From: Richard Hart [REDACTED]
Sent: 03 December 2020 21:33
To: Planning <Planning@arun.gov.uk>
Subject: Fwd: Objection to Planning Application - AB/114/20/PD

Objection to Planning Application

AB/114/20/PD
Riverside House

2 Fitzalan Road
Arundel
BN18 9JS

Drawing Title:
PROPOSED ELEVATIONS

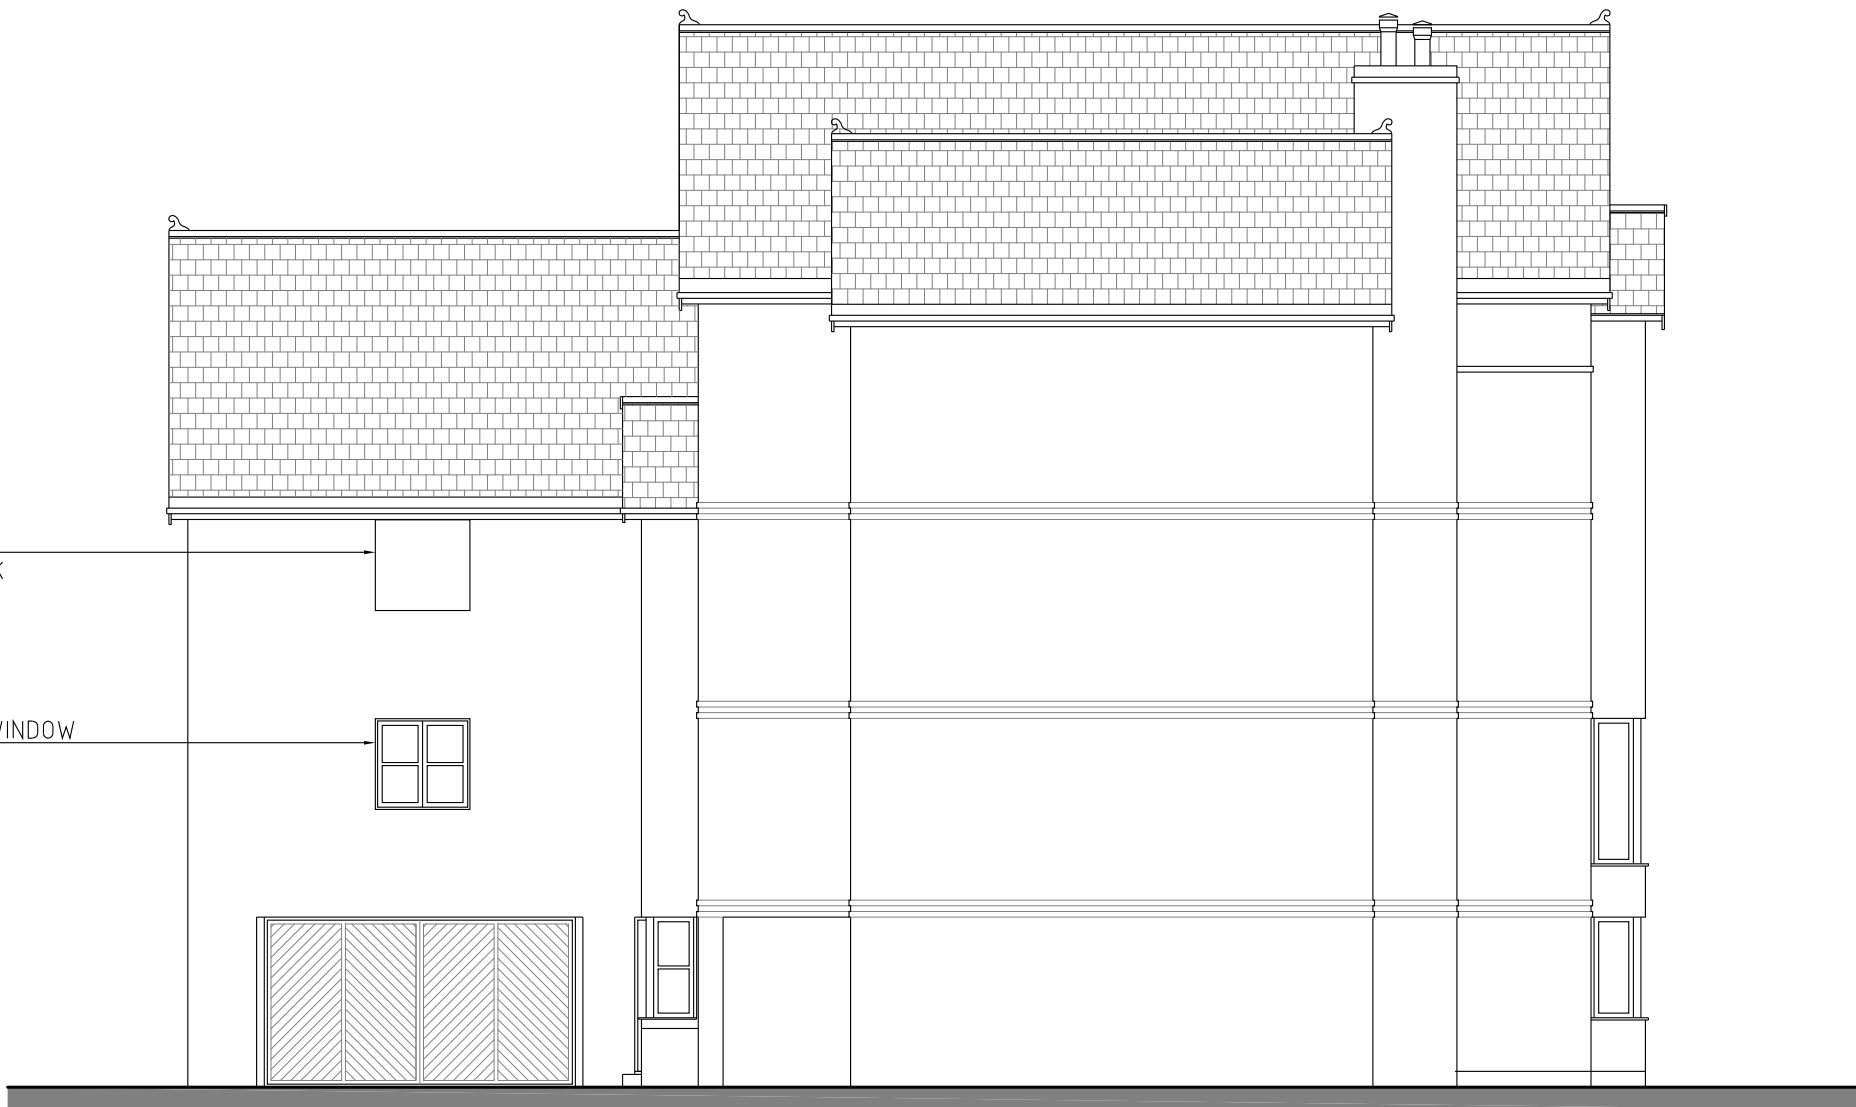
1. The proposed increase of two additional floors considerably raises the elevation, nearing the height of the Martlets Court building which in itself breached planning regulations when it was built. The relative height of Martlets should not therefore be used as a justification to increase the height of other buildings in the vicinity which is essentially a low-rise residential area.

2. The benchmark for new buildings should respect the other 2-story buildings of Fitzalan Road in keeping with the streetscape, or we set a dangerous precedent by gradually increasing building height along the east bank of the Arun.

3. The proposed elevation will obscure the view into and out of the Arundel Conservation Area, much to its detriment.
4. I note from the plans that there are some eleven proposed bathrooms, the future intent for which is surely a multi-occupancy dwelling of several flats. If this is indeed the case it should be declared as such, and not become an example of incremental development by stealth. If the intent is for a multi-occupancy building then parking requirements should be appropriately scaled, and the increase in traffic taken into consideration at this stage of the planning application.
